National Highways Planning Response (NHPR 25-01) Formal Recommendation to an Application for Planning Permission

Council's Reference: 2025/92161

Location: Land adj, 17, Whitehall Road West, Birkenshaw, BD11 2LS

Proposal: Discharge of details reserved by conditions 4-8 (intrusive investigations), 11 (Remediation Strategy and Verification Report), 12 (CEMP), 13 (noise), 14 (Arboricultural Method Statement), 15 (CMP), 16 (highway), 17 (visibility), 18 (Safety Audit), 19 (estate streets), 20 (waste collection), 21 (surface water attenuation), 24 (bin storage), 25 (bicycle storage), 26 (drainage), 28 (drainage), 29 (CEMP: Biodiversity), 30 (landscape), 34 (solar panel array), 35 (materials), 38 (boundary treatments) on previous permission 2024/92281 for erection of 23 dwellings

Title: Surface Water Attenuation Tank
 and External Works

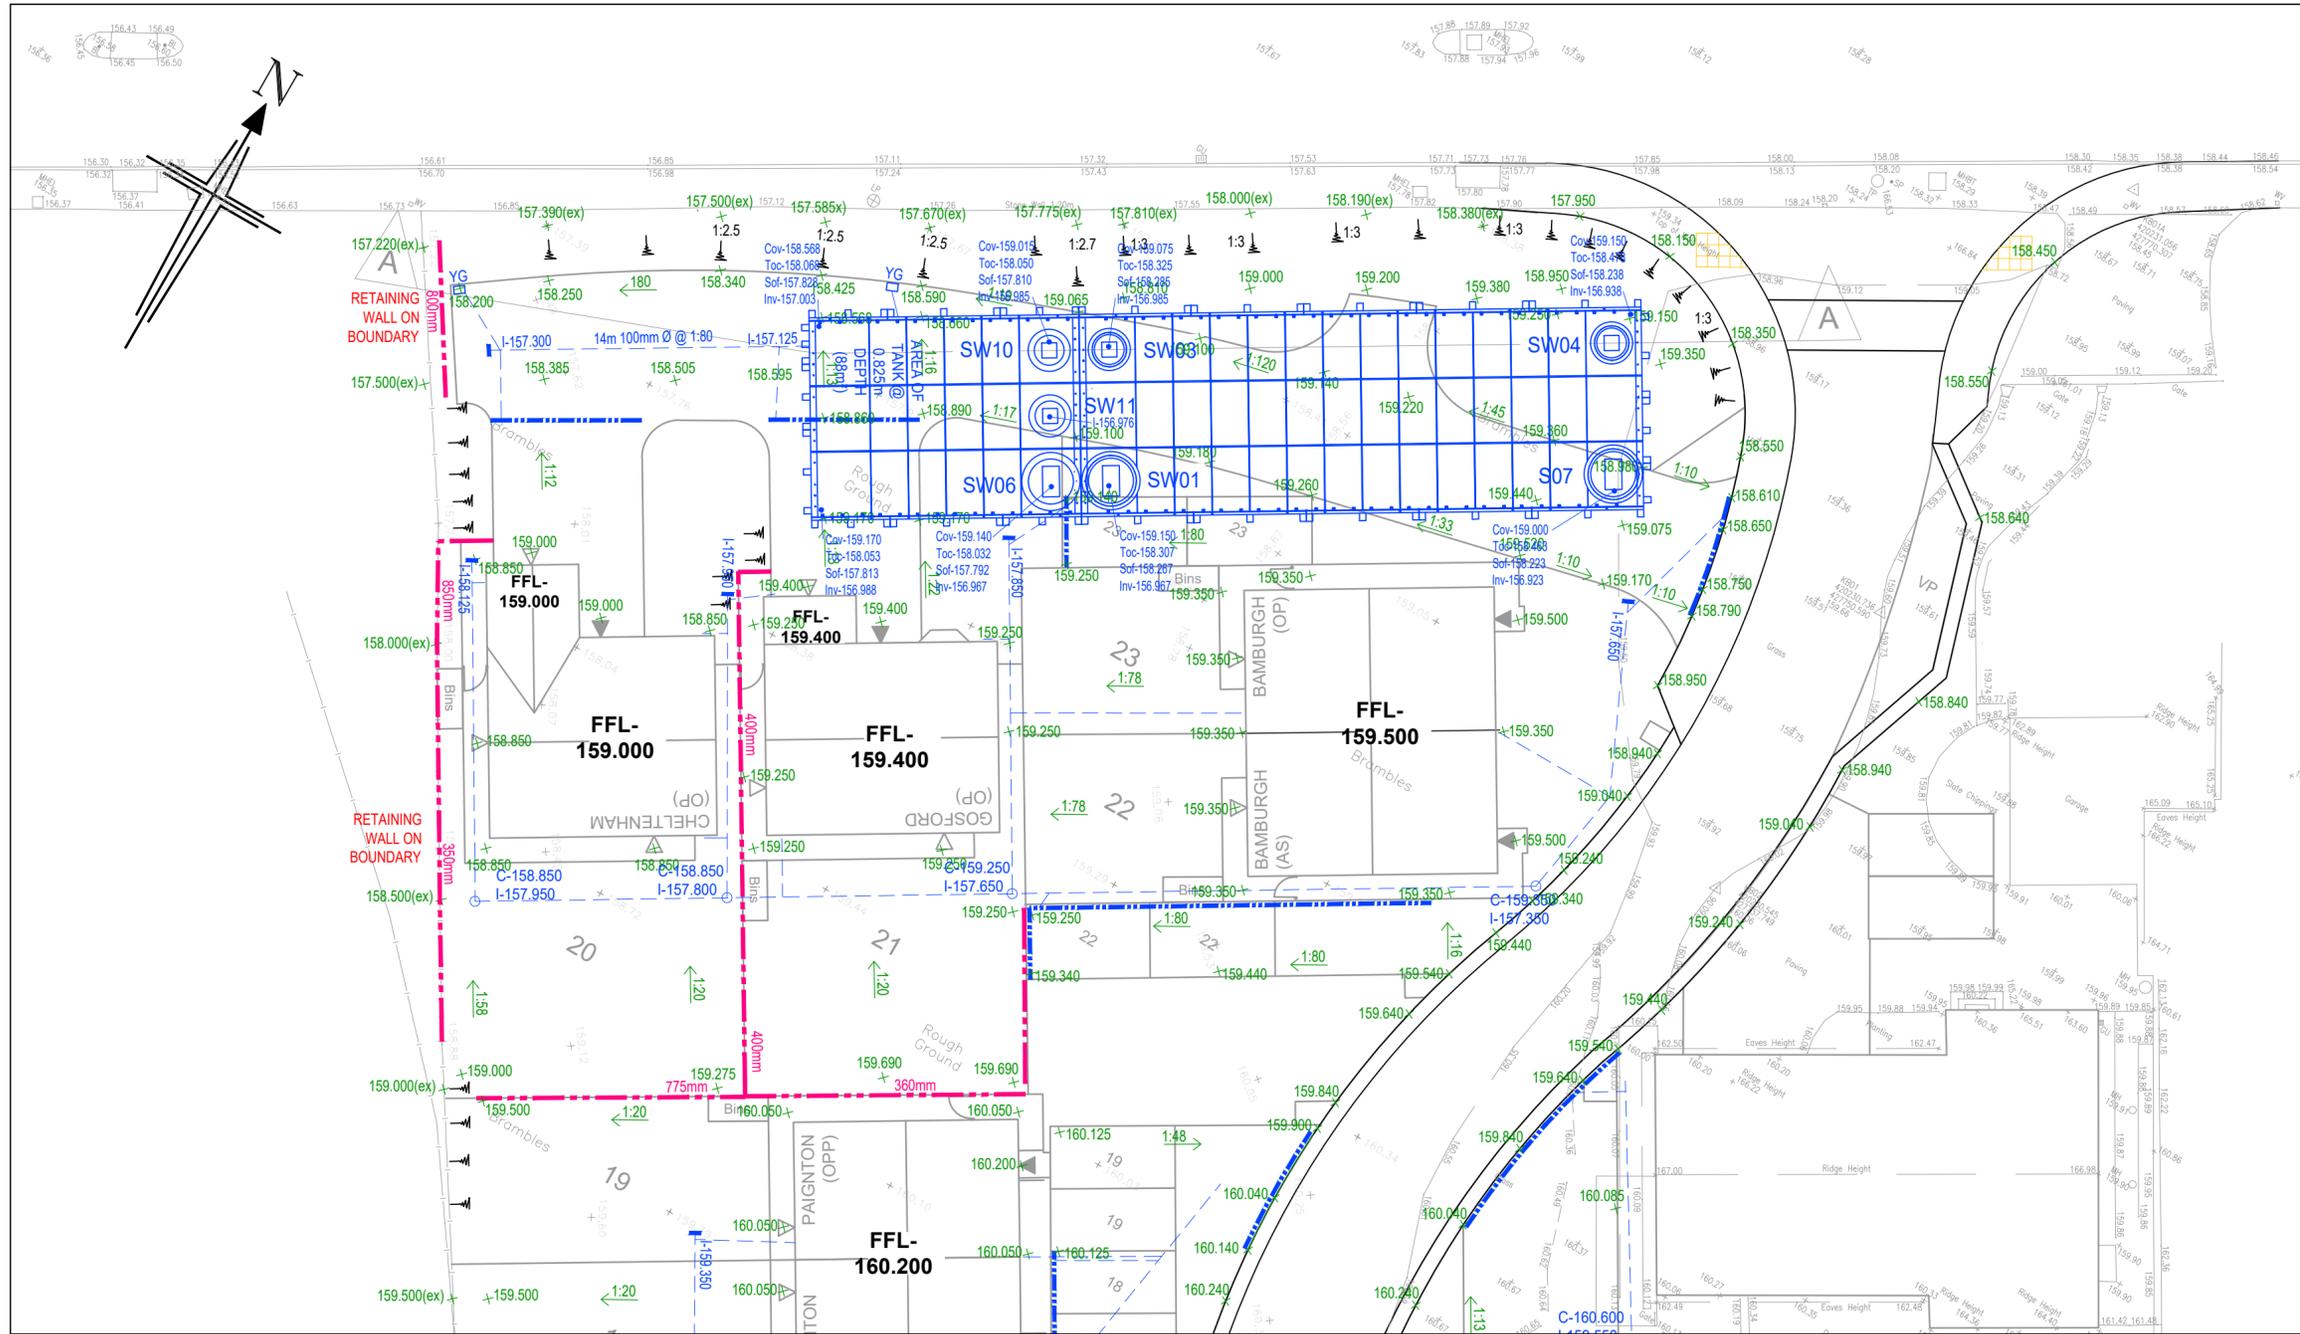
Condition 28 - Before development commences above foundation level, a detailed maintenance and management regime for the storage facility including the flow restriction shall be submitted to and approved in writing by the Local Planning Authority. This shall include a risk assessment applied prior to a method statement consisting of a schedule and itinerary of tasks including access to and into the specific attenuation and flow control arrangements for this site. The approved maintenance and management scheme shall be implemented thereafter.

However, it is unclear if Yorkshire Water are also adopting the hydro brake flow control that will restrict surface water run-off to 6l/s. As riparian owners of the downstream watercourse this particular element of the strategy is of particular interest to National Highways, and we seek surety that an appropriate management and maintenance regime will be in place. The Applicant is asked to clarify this position and provide relevant information on the management & maintenance scheme.

Drawing No: 23/341/050/001
Job No: 23-341
Revision: L
Date: 21.02.24

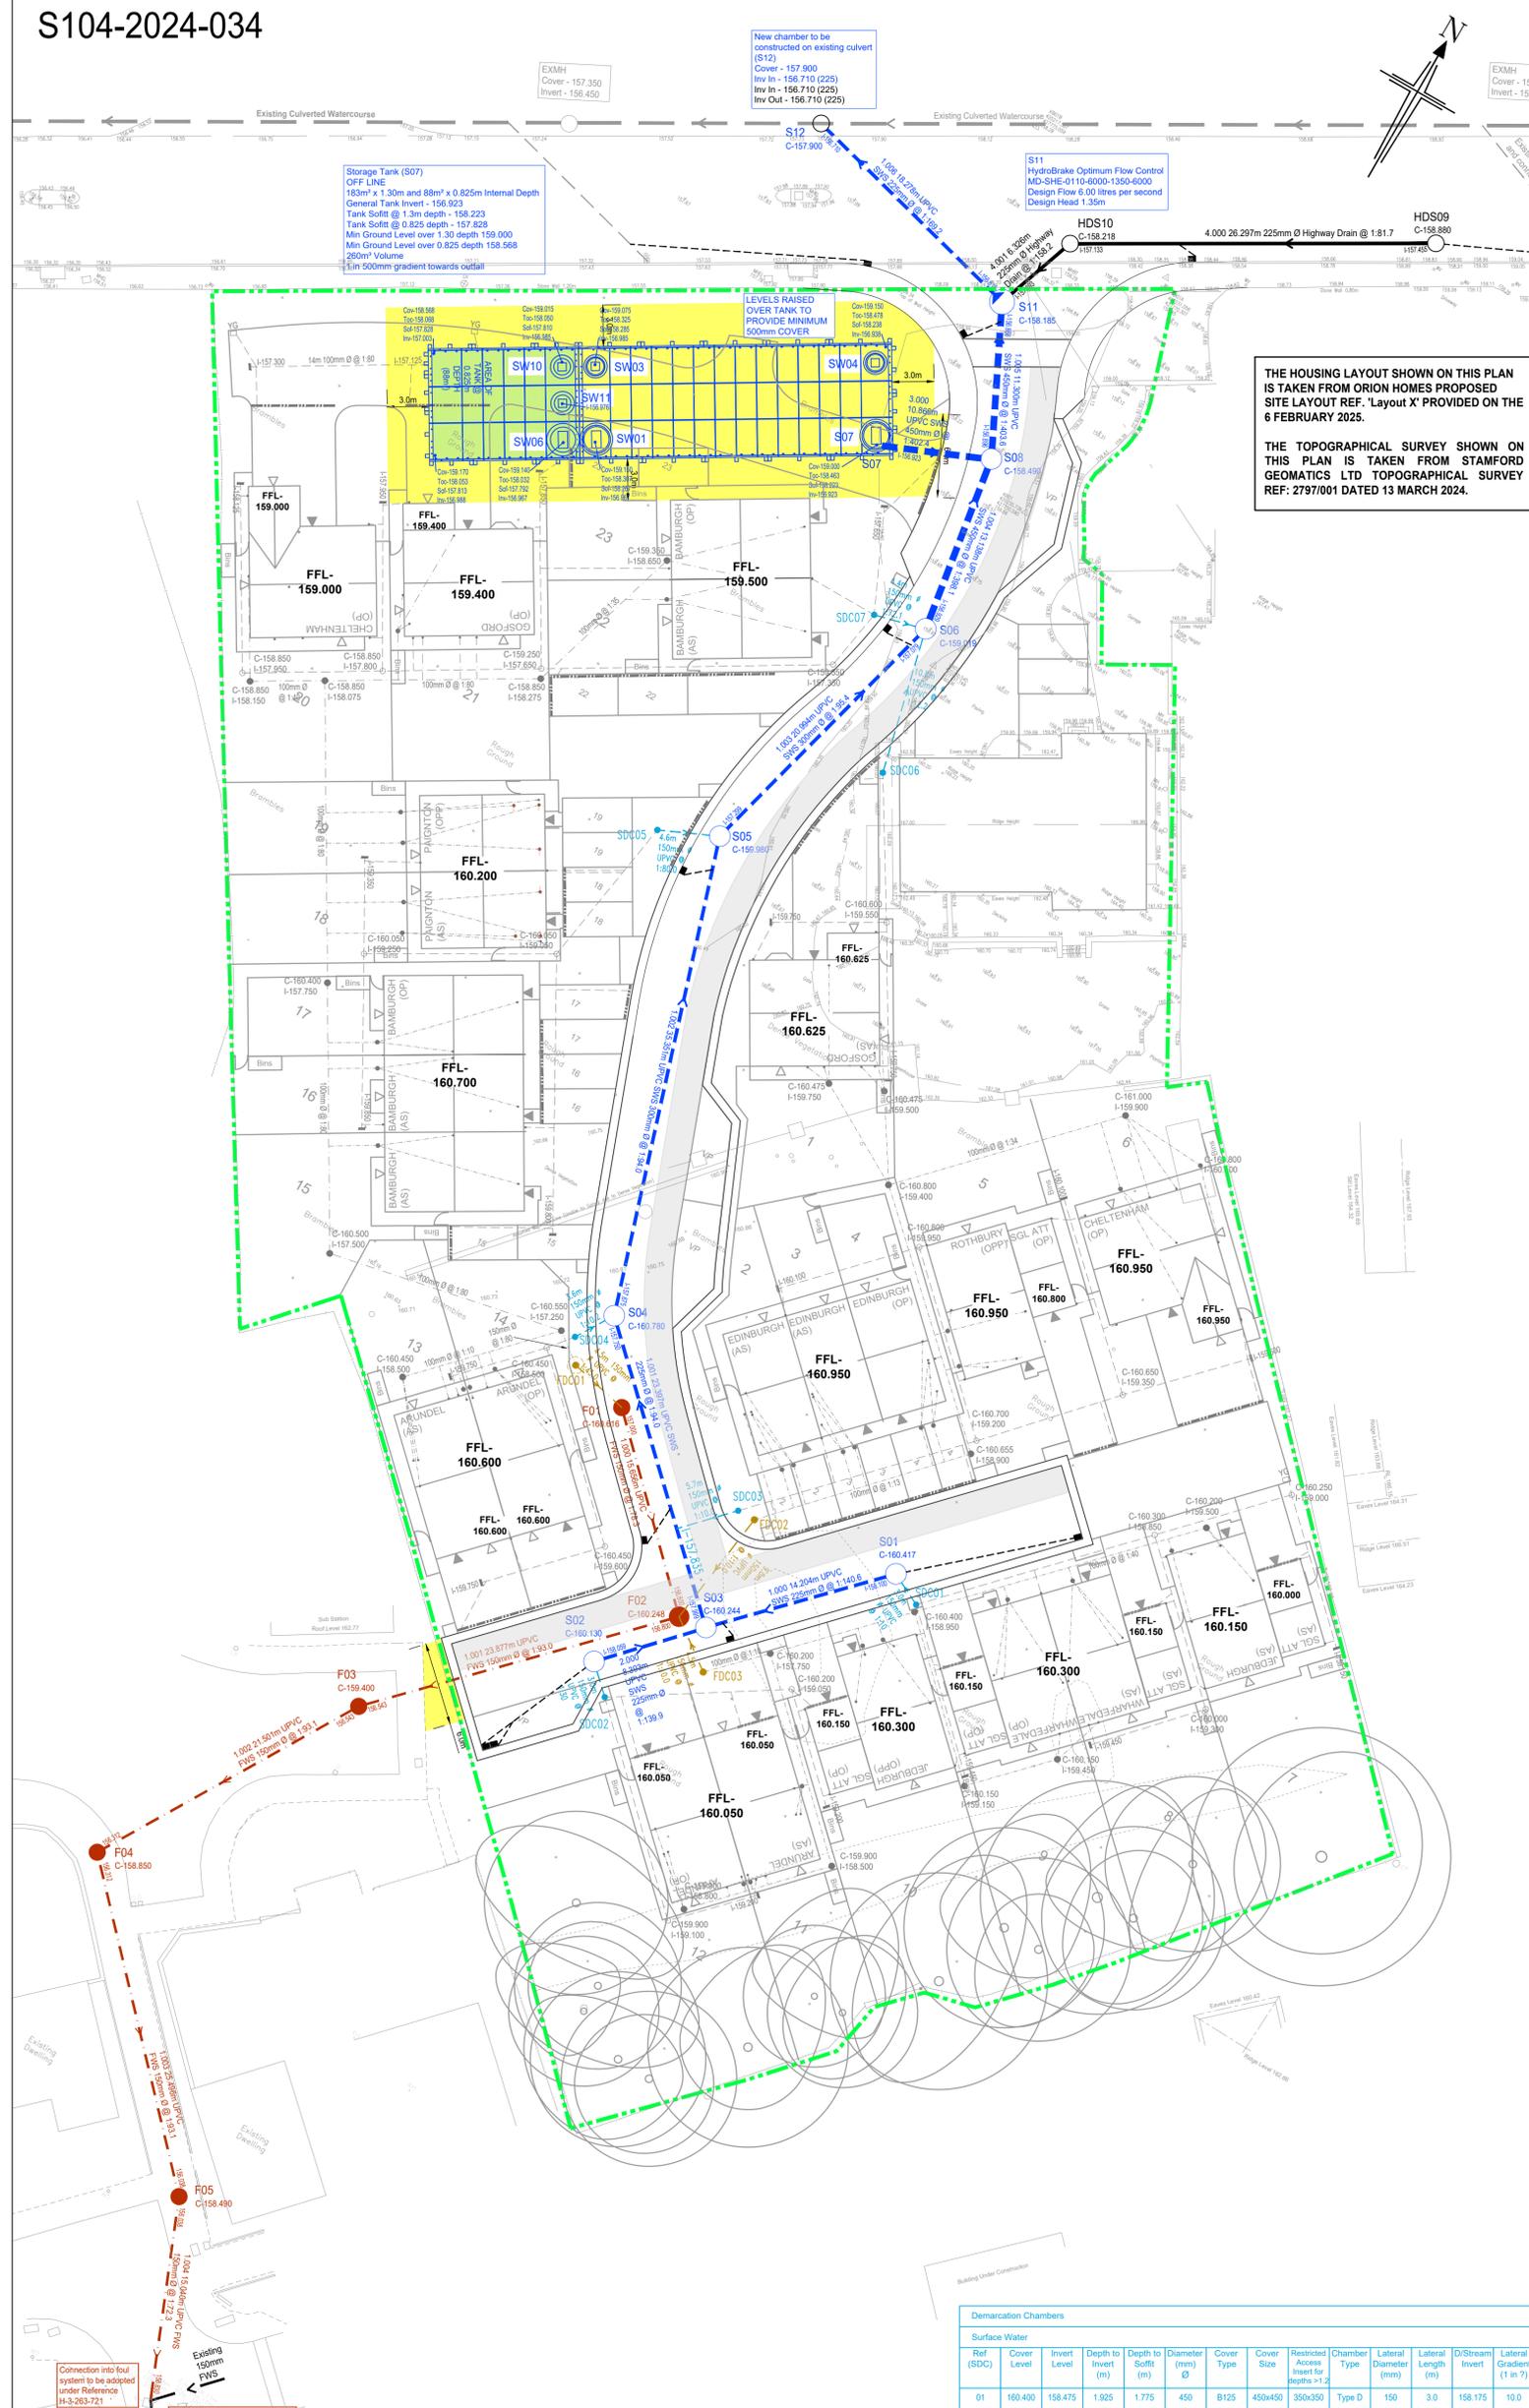
It is noted that the Applicant has submitted the following statement:

The concrete sectional tank is to be adopted by Yorkshire Water under a S106 agreement. Therefore, we do not need a maintenance and management regime in place.

Title: Construction Silt / Sediment and Temporary Surface
Water Management Plan

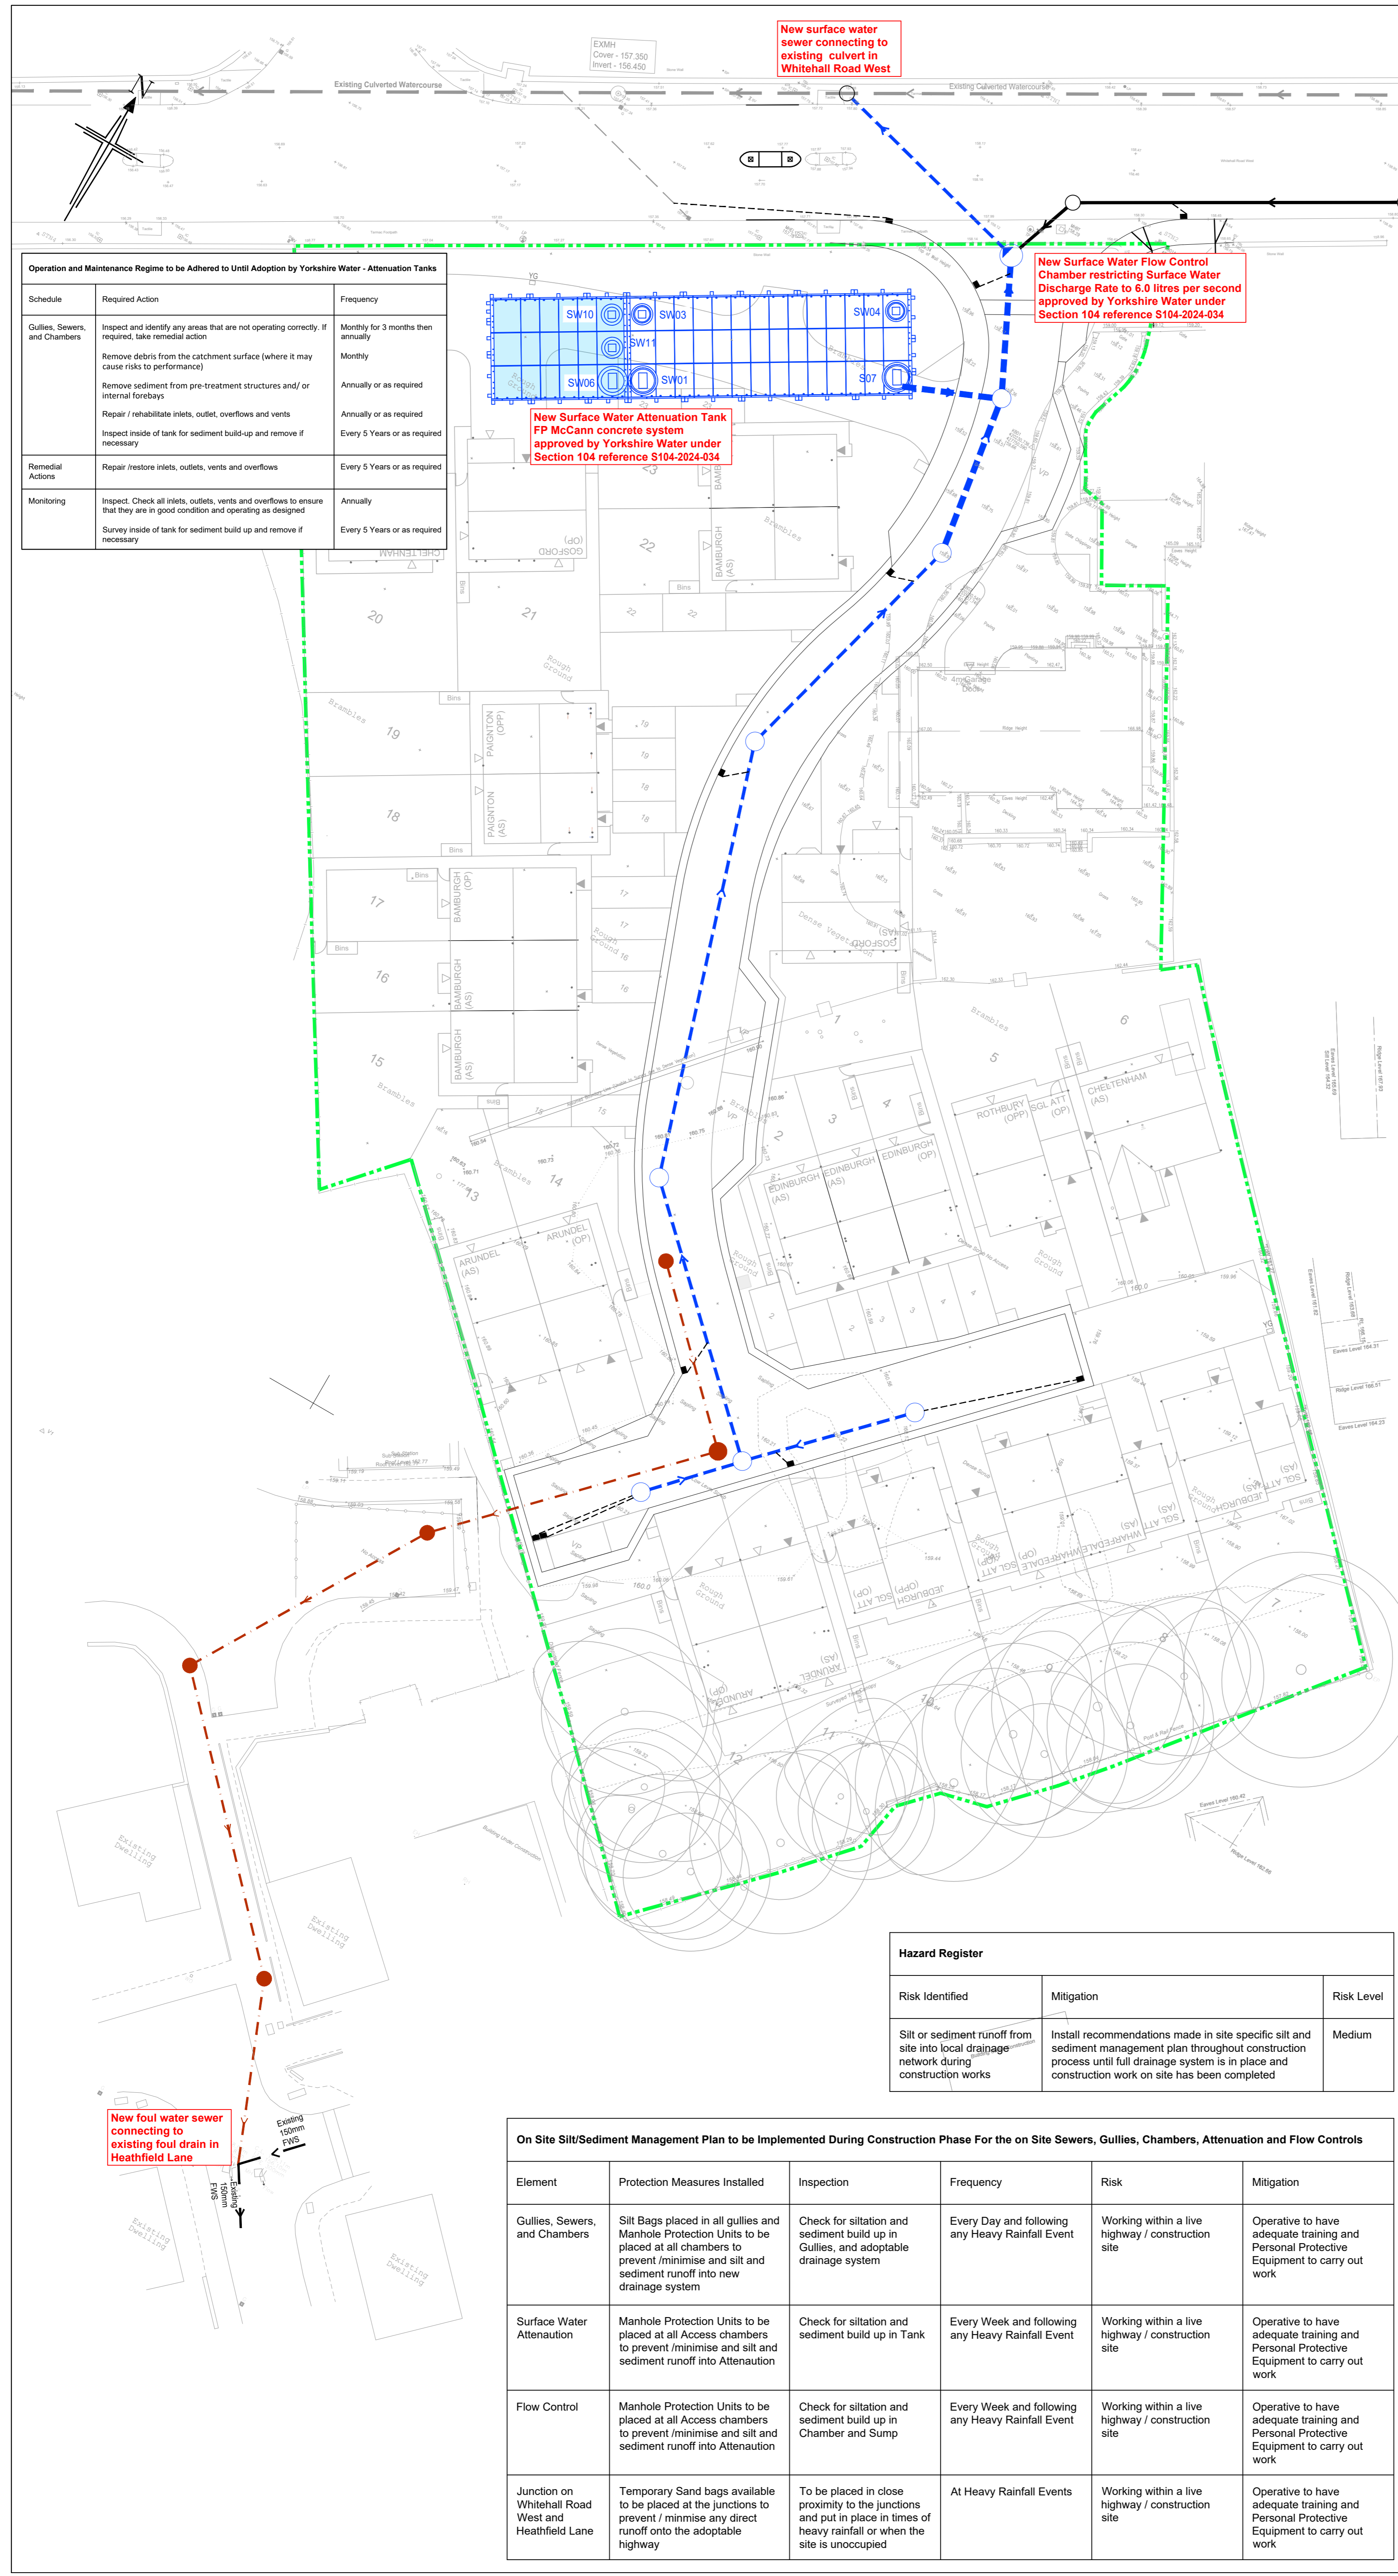
In addition, whilst it is noted that on site wheel wash facilities are to be provided there is no reference to how the site will manage the potential for debris on the public highway. Will there be a monitor and clean regime in place, and if so, how will this be deployed or will laden HGVs be sheeted? This should be made clear in the construction management plan.
